Our Ref: 2023/455039
File No: R/2017/25/N
Your Ref: SSD-8925-Mod-11

New Sydney Fish Markets – SSD 8925 Mod 11 – Advice on Modification

The modification relates to a proposed change of the approved road levels of Bridge Road involving the reduction of height of Bridge Road by a metre (to a level similar to its existing level), and as a result amendments to the height of bus/taxi bays, and landscaping across the Bridge Road frontage of the Sydney Fish Markets.

Title: SIGNAGE AND LINEMARKING PLAN SHEET 1

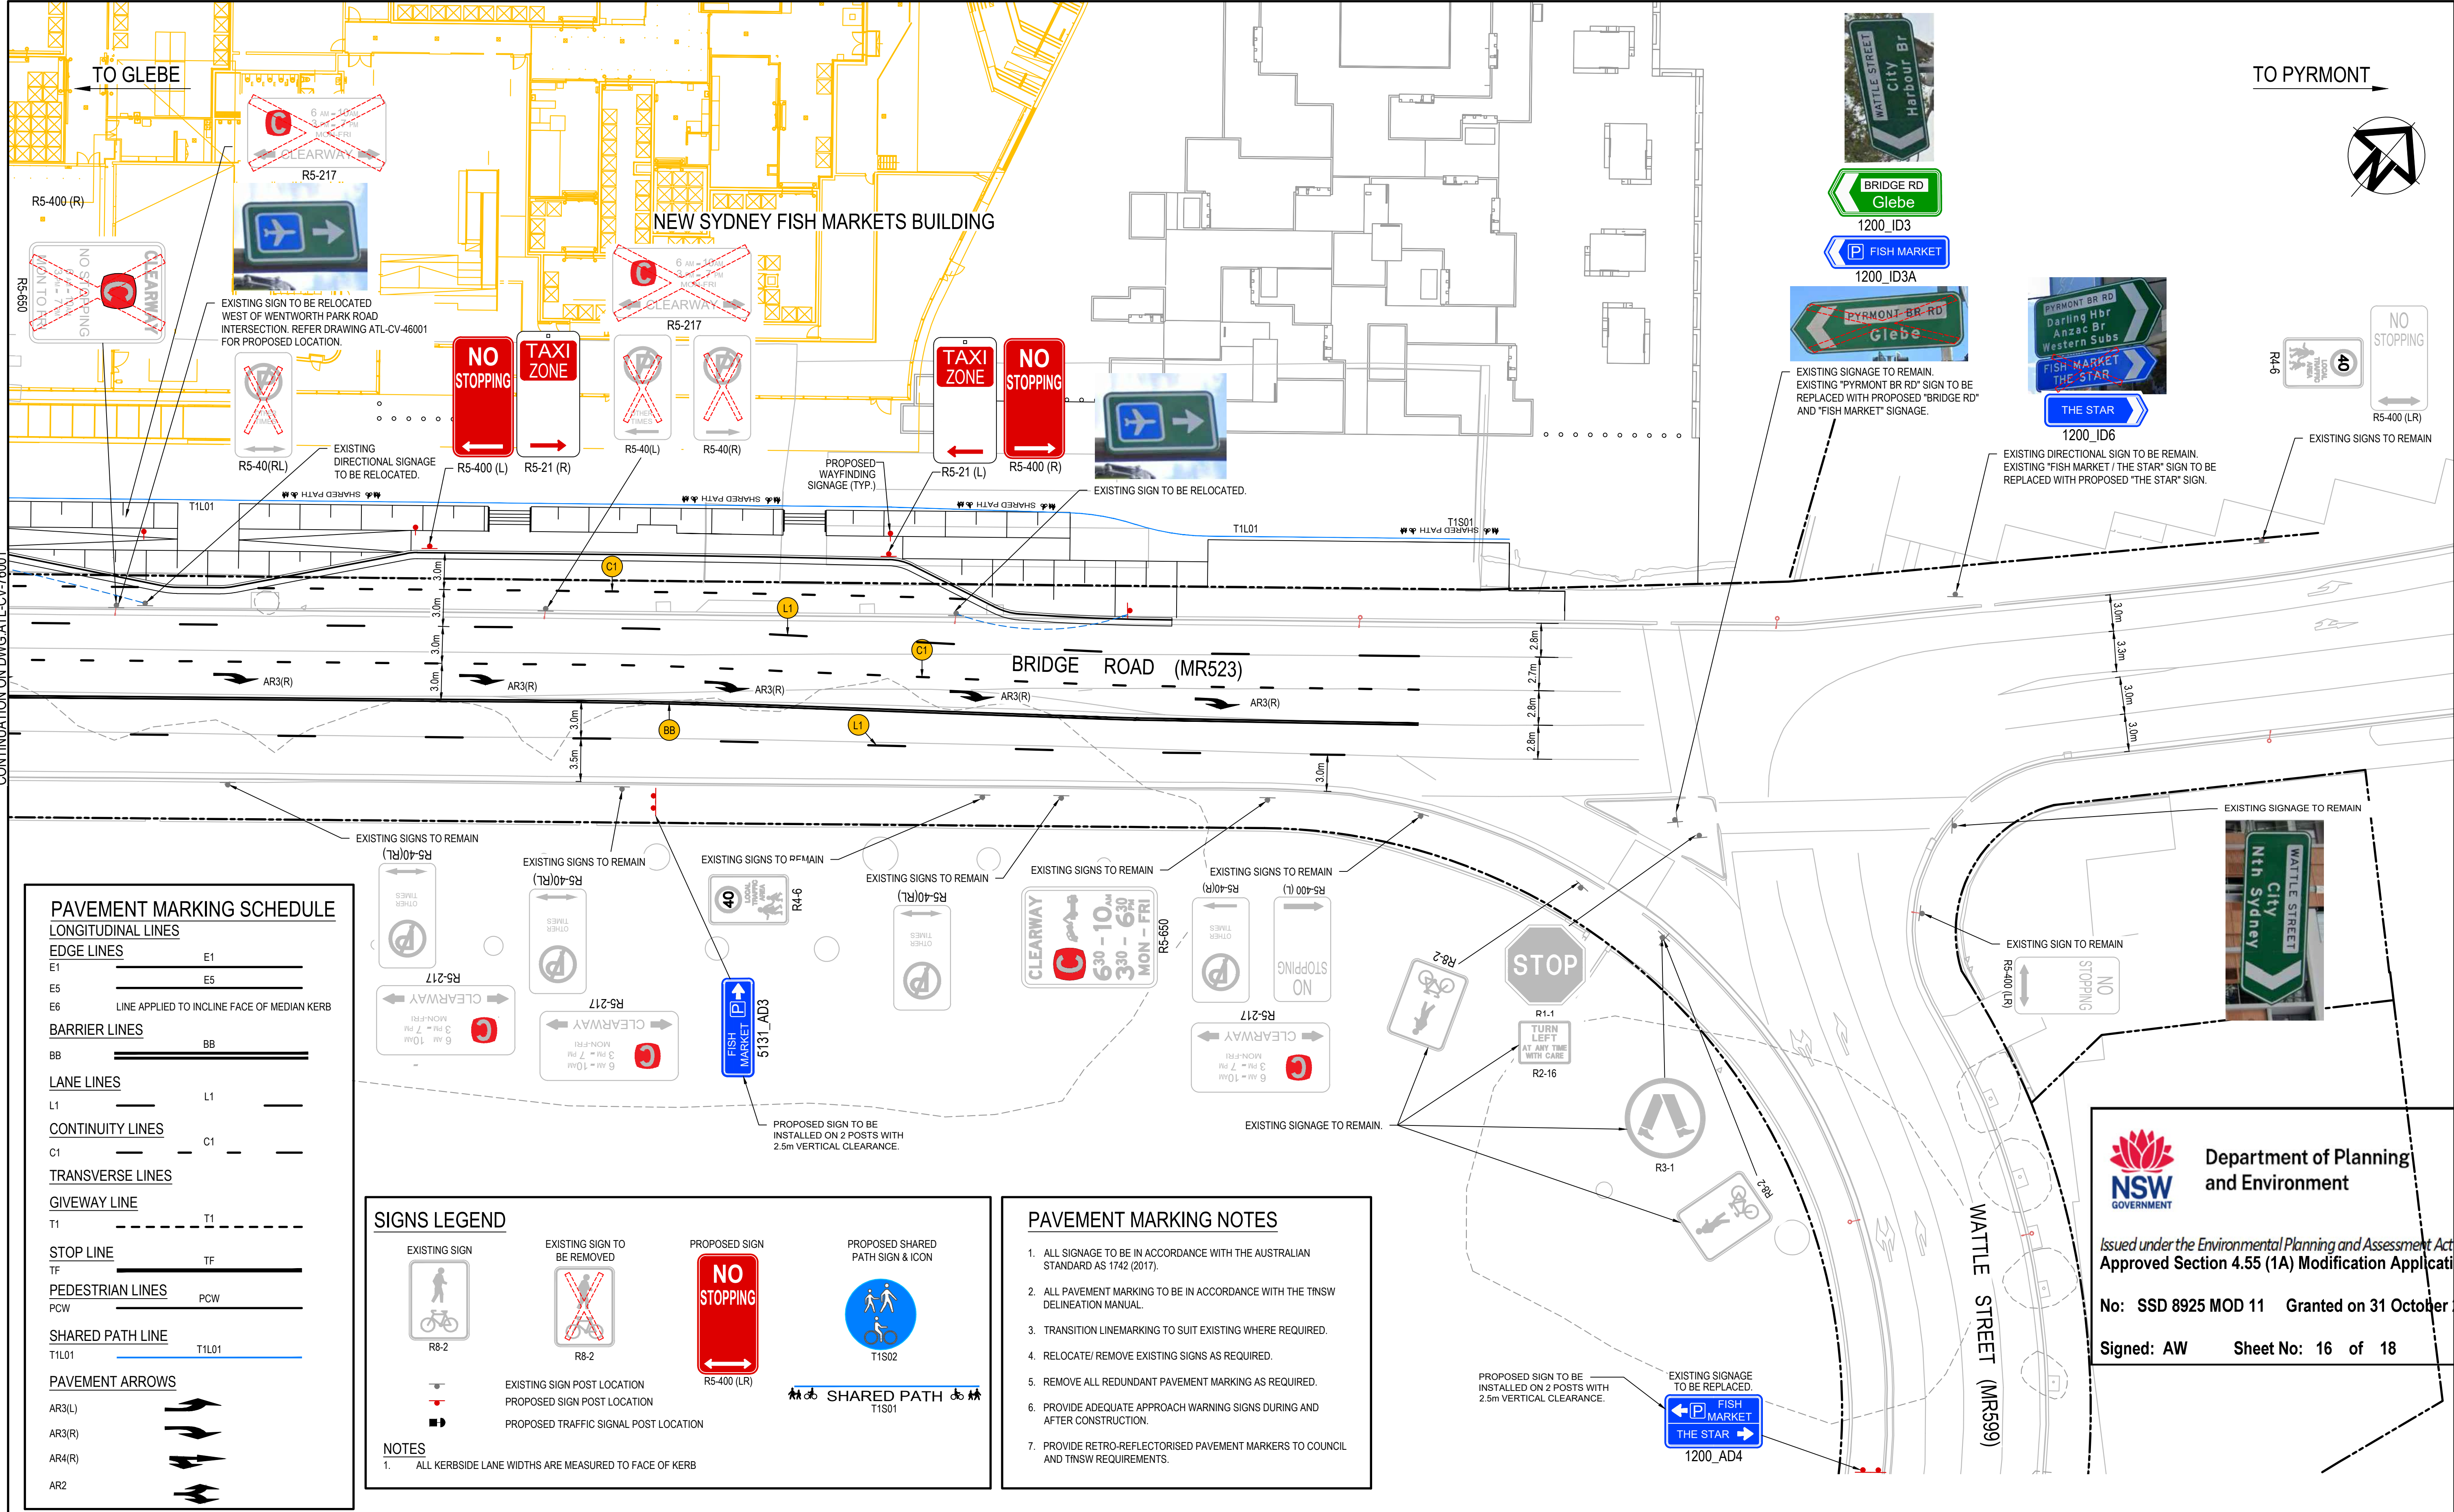
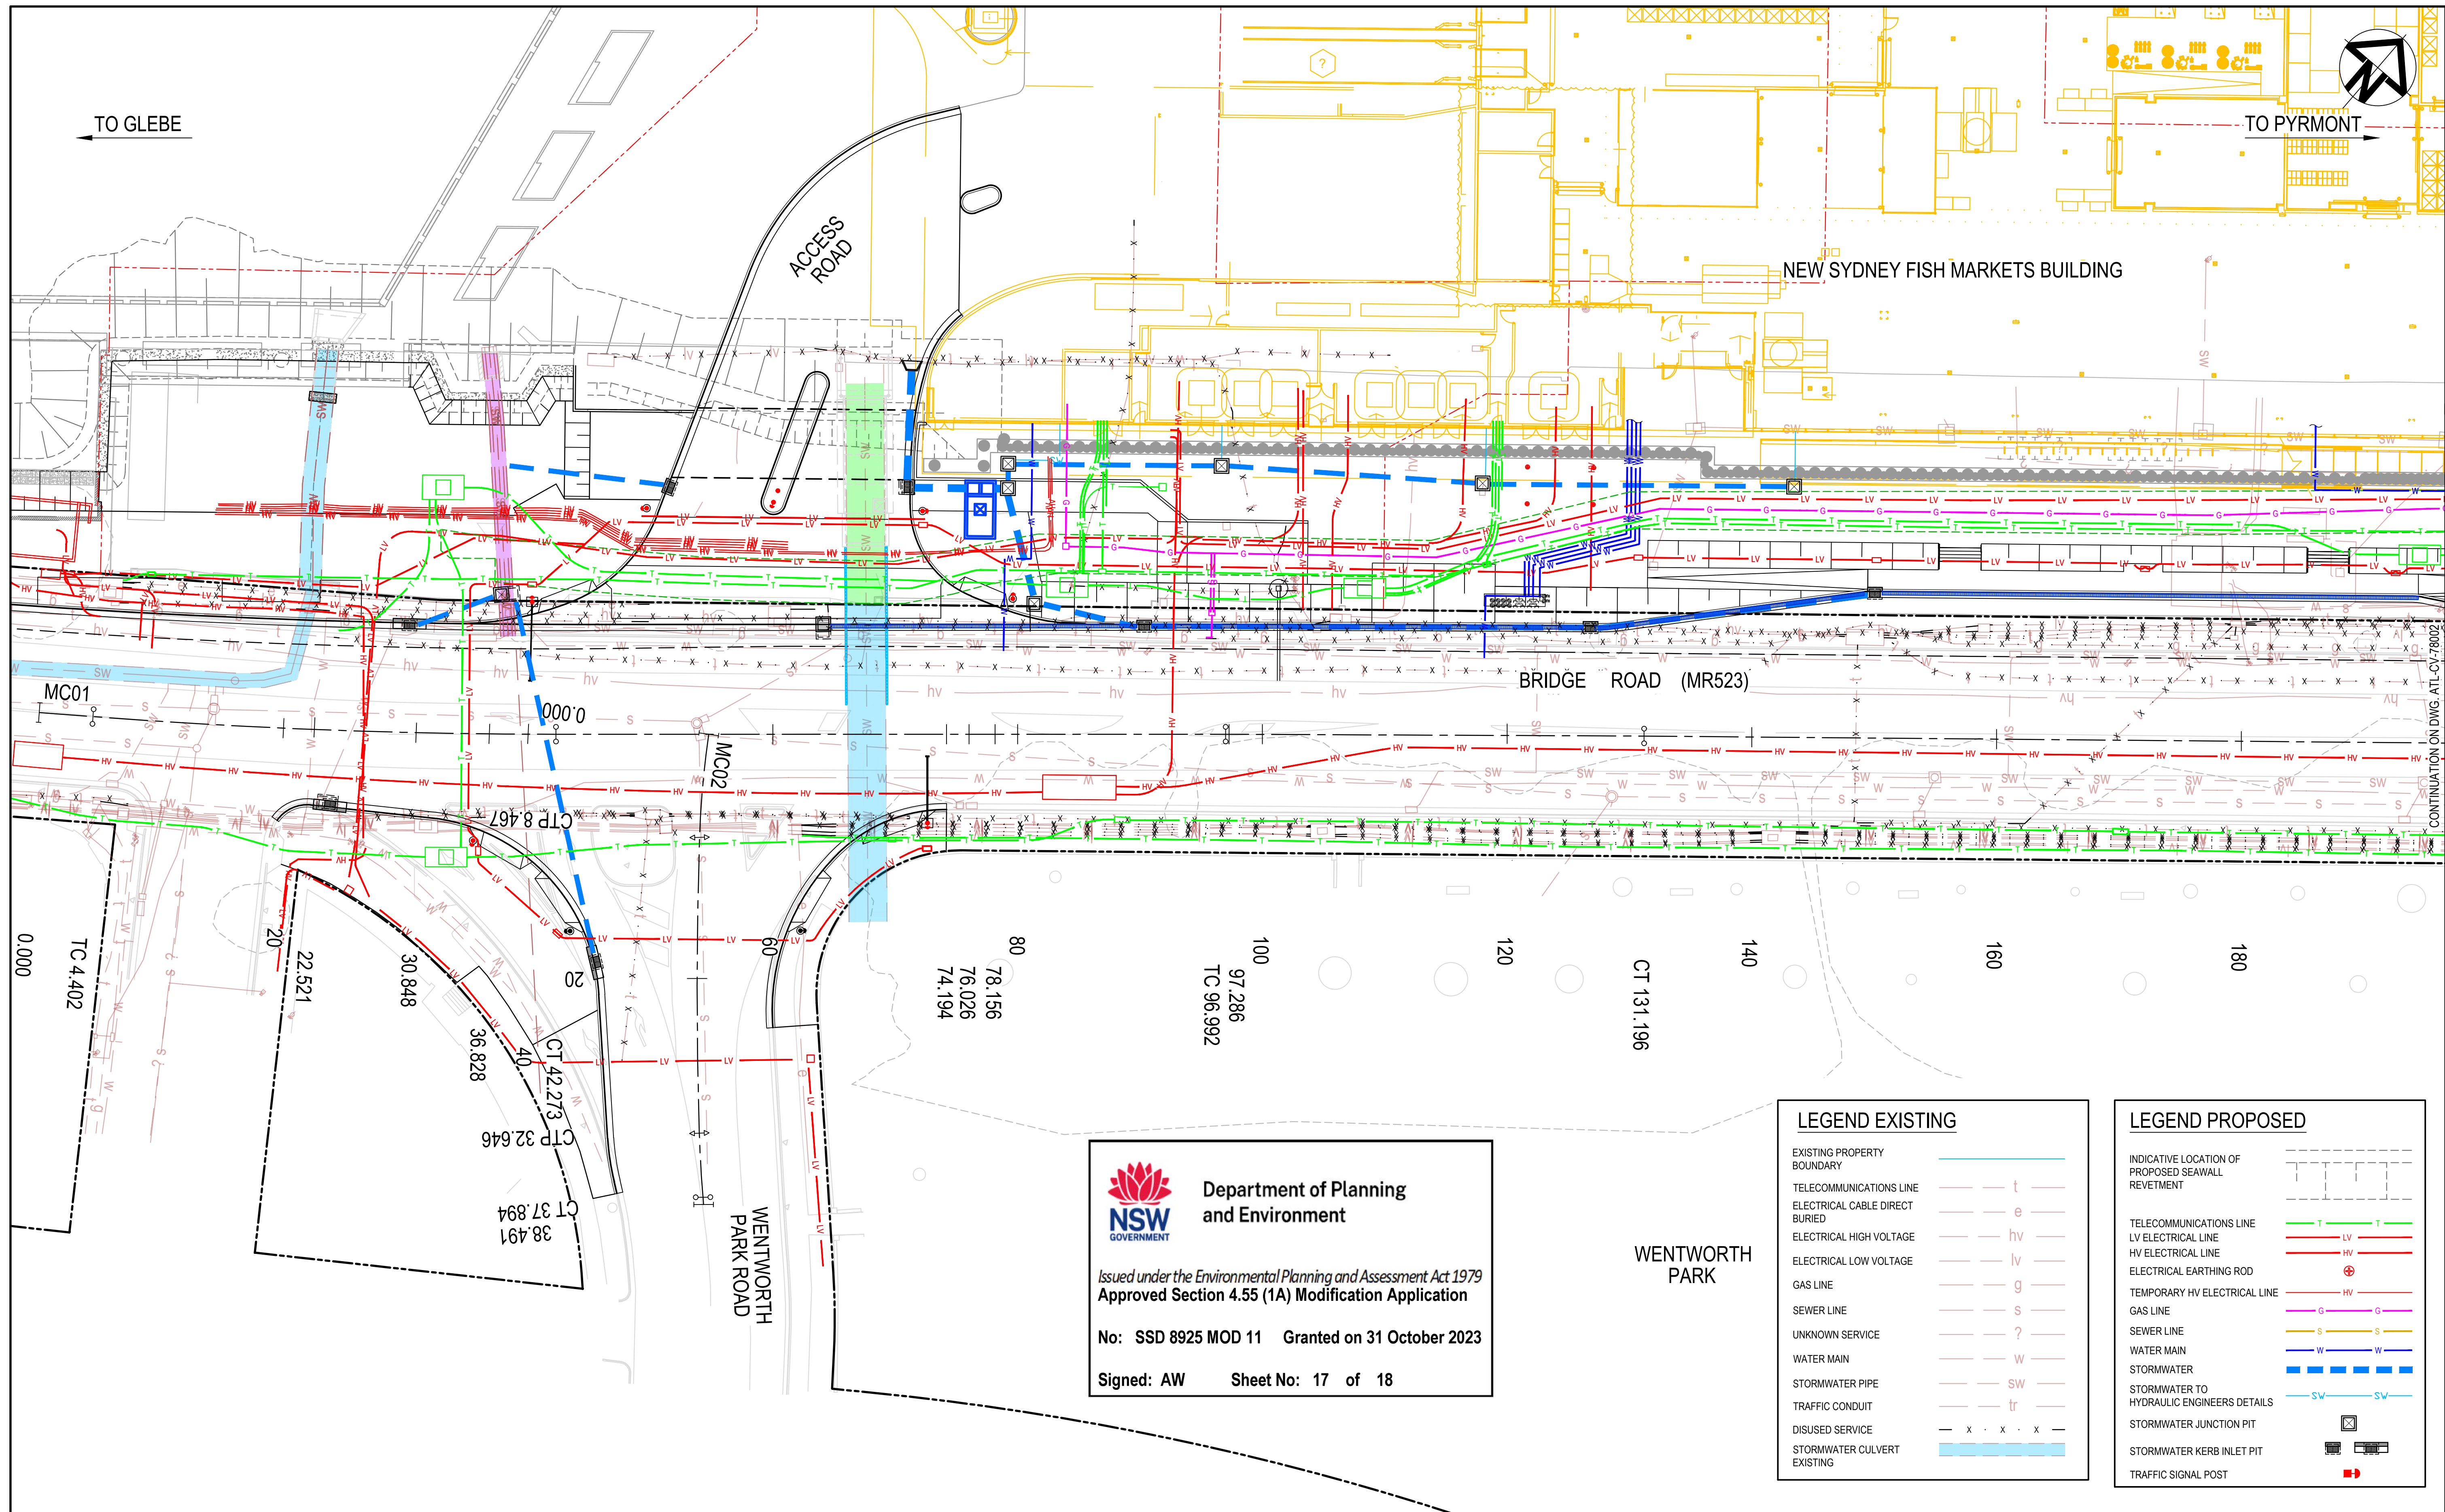
The City recommends the median along Bridge Road be painted rather than constructed in concrete to allow future flexibility as the City, the proponent and Transport for NSW continue discussions.

Additionally, the modification application was accompanied by a road design plan including stormwater, pavement, signage-line marking and utility plan, prepared by AT&L. This plan is not approved by the City at this stage. As Bridge Road is a State-controlled road, any road design and associated infrastructure design must first be approved by Transport for NSW. No changes to the previous conditions are required.
